**Subject:** FW: Planning applications 3/2012/0198 and 3/2012/0199 Backridge House, Twitter Lane, Bashall Eaves

**Subject:** Planning applications 3/2012/0198 and 3/2012/0199 Backridge House, Twitter Lane, Bashall Eaves

Site plan & elevations of dry stone walls as proposed

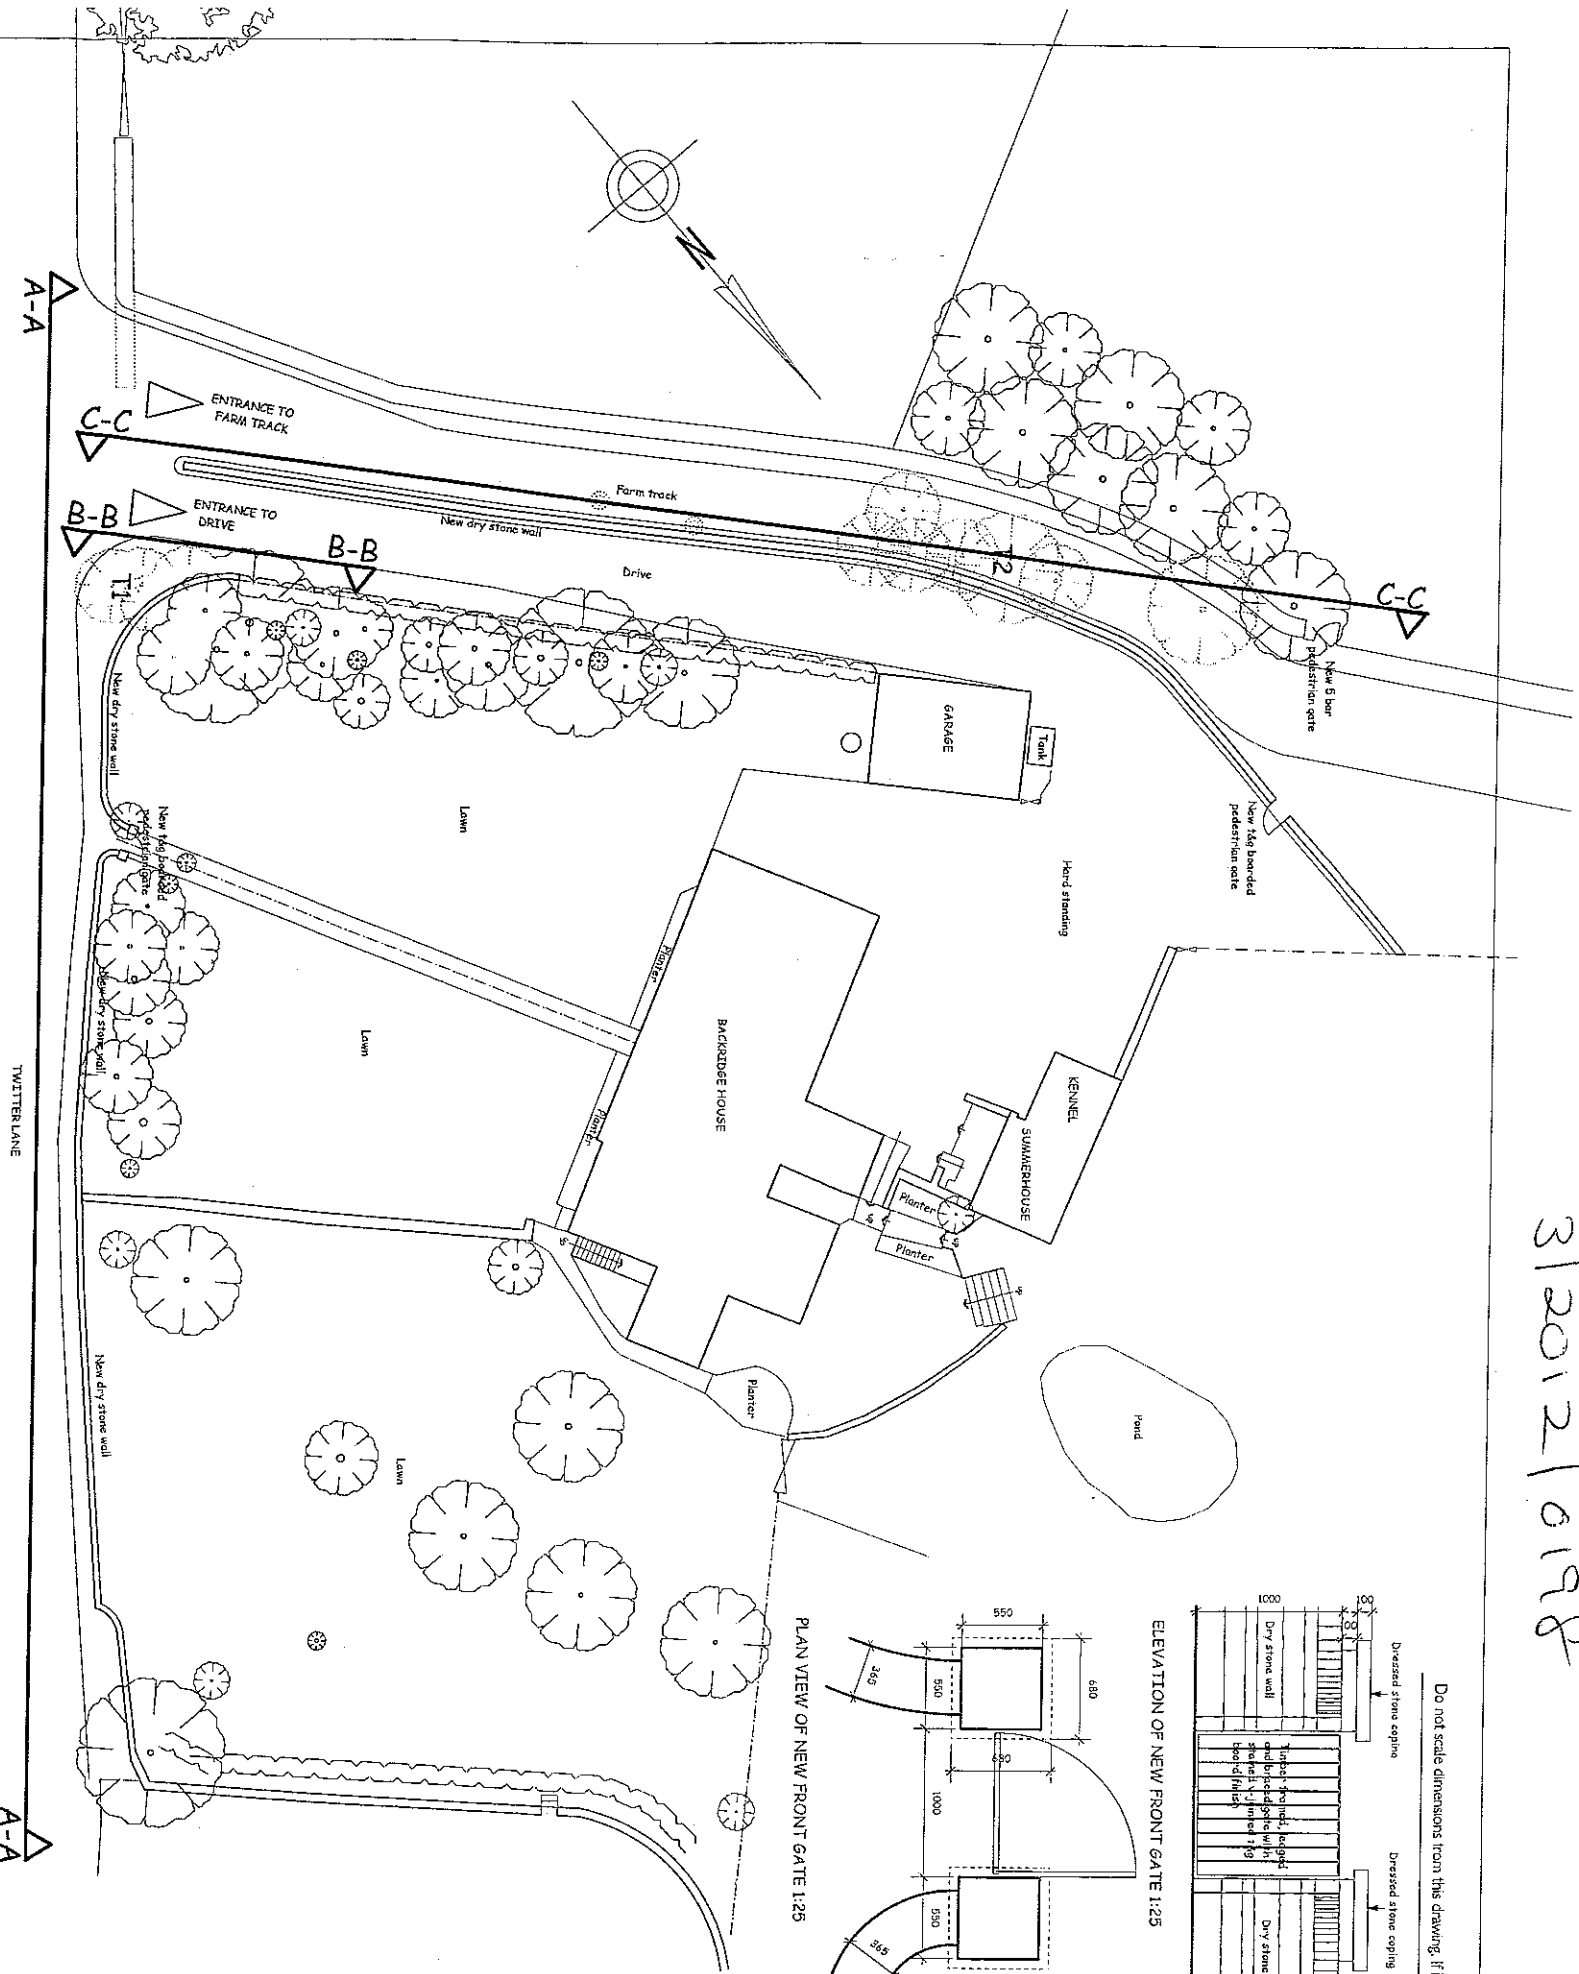
1. Any gateposts erected at the accesses shall be positioned 10 metres behind the nearside edge of the carriageway of Twitter Lane. The gates shall open away from the highway. Reason: To permit vehicles to pull clear of the carriageway when entering the site.

Drawing No: SCP/11222/SK01 Rev: D

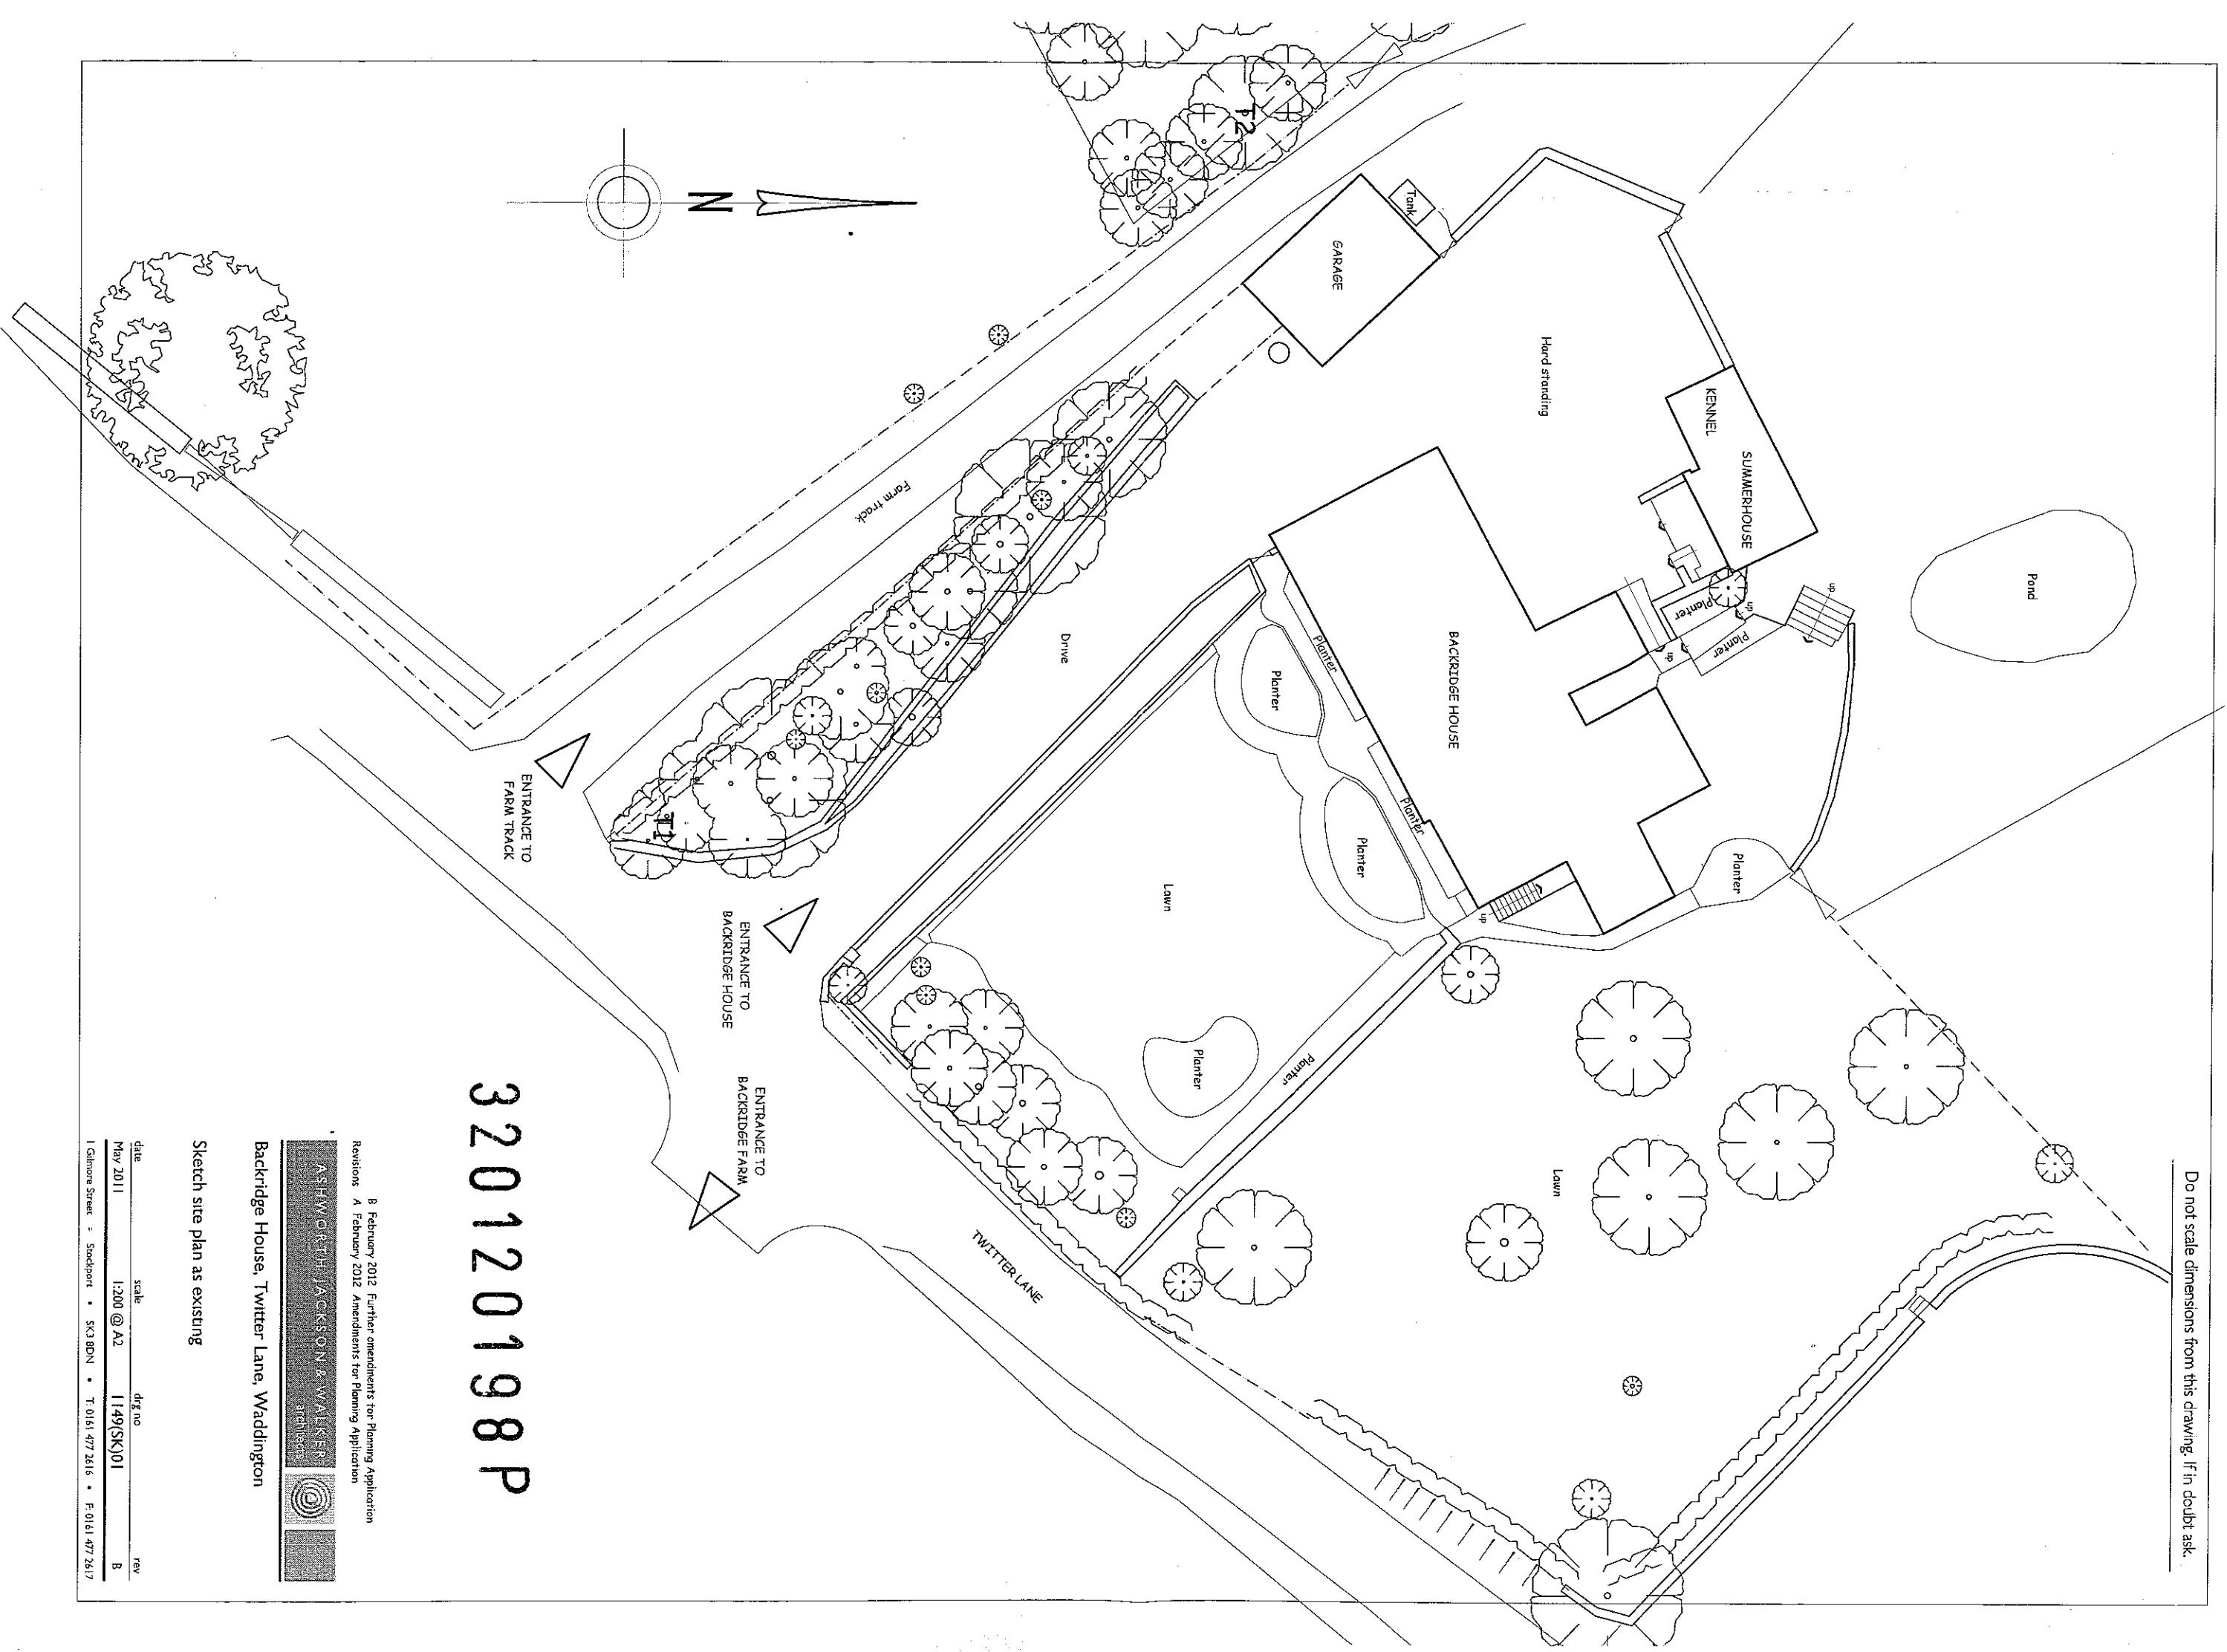
The proposed access arrangements represent a considerable improvement on the current layout and therefore I have no objection to the proposals, subject to the following conditions:

2. Before the accesses are used for vehicular purposes, that part of the accesses extending from the highway boundary for a minimum distance of 20 metres shall be appropriately paved in tarmac, concrete, block pavements, or other approved materials. Reason: To prevent loose surface material from being carried onto the public highway thus causing a potential source of danger to other road users.

3. The existing residential access driveway to Backridge House shall be physically and permanently closed and the verge shall be reinstated. Reason: To limit the number of access points to the highway at this location in the interests of road safety.
